Application Reference: 2025/0337

Location: 79 Barnsley Road, Dodworth, Barnsley, S75 3JS.

This application seeks planning permission for the retention of sliding metal gates in the gap of the front boundary wall approved under application 2024/0645.

**Proposed Site Plan**

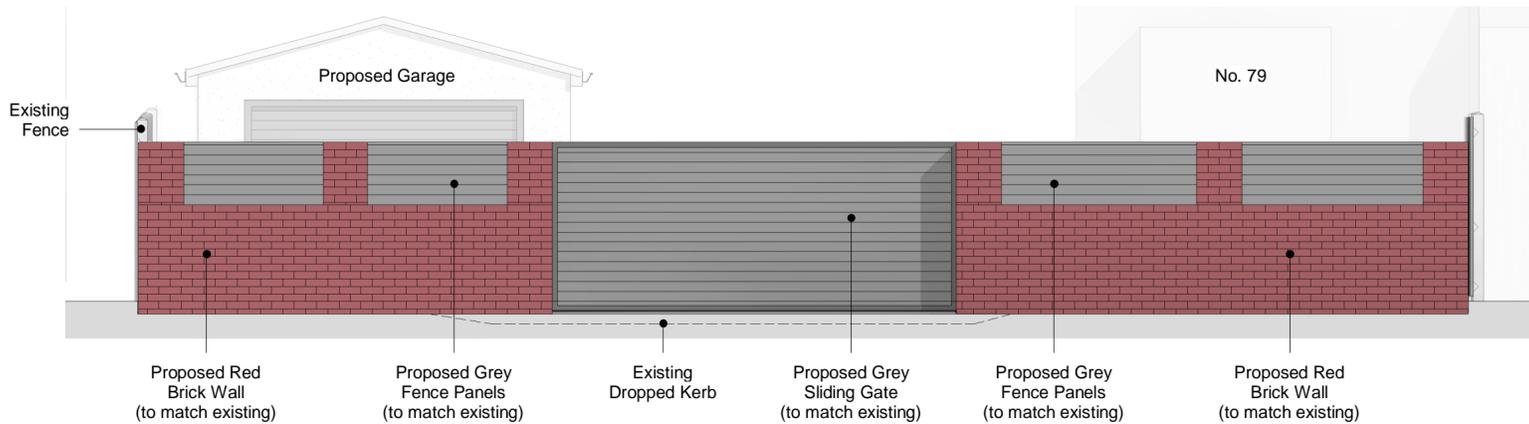
Highways Development Control were consulted, who stated there were concerns with the proposal in terms of highway safety as the gates should be set back by a minimum distance of 5 metres from the edge of the public highway to ensure that vehicles are able to pull clear of the adopted highway and avoid becoming an obstruction to approaching vehicles and pedestrians. Vehicles entering the site cannot park directly opposite due to the presence of a bus stop, and while the submitted statement suggests that the applicant could park on the site side of the road, it is unclear whether a vehicle would then be able to enter the site from this angle of approach, especially due to the restricted access width because of the presence of a street lighting column within the area of entry. It is noted that the supporting statement states that the gate would be electronically operated and remotely controlled, allowing it to be opened upon approach and enabling entry without stopping. However, a situation could arise whereby the gates fail to operate as expected, which has the potential to cause confusion for road users. Consequently, the proposal is viewed unfavourably from a highway perspective and is considered prejudicial to highway safety and efficient, contrary to Local Plan Policy T4. The LPA has no reason to disagree with the concerns raised in this instance.

Whilst the Applicant has suggested that the requirement for the gates to be electronically operated and remotely controlled could be secured by a planning condition, such a condition is not considered to meet the relevant tests set out by paragraph 57 of the NPPF.

The proposal is therefore considered contrary to Local Plan Policy T4: New Development and Transport Safety and is considered unacceptable regarding highway safety.
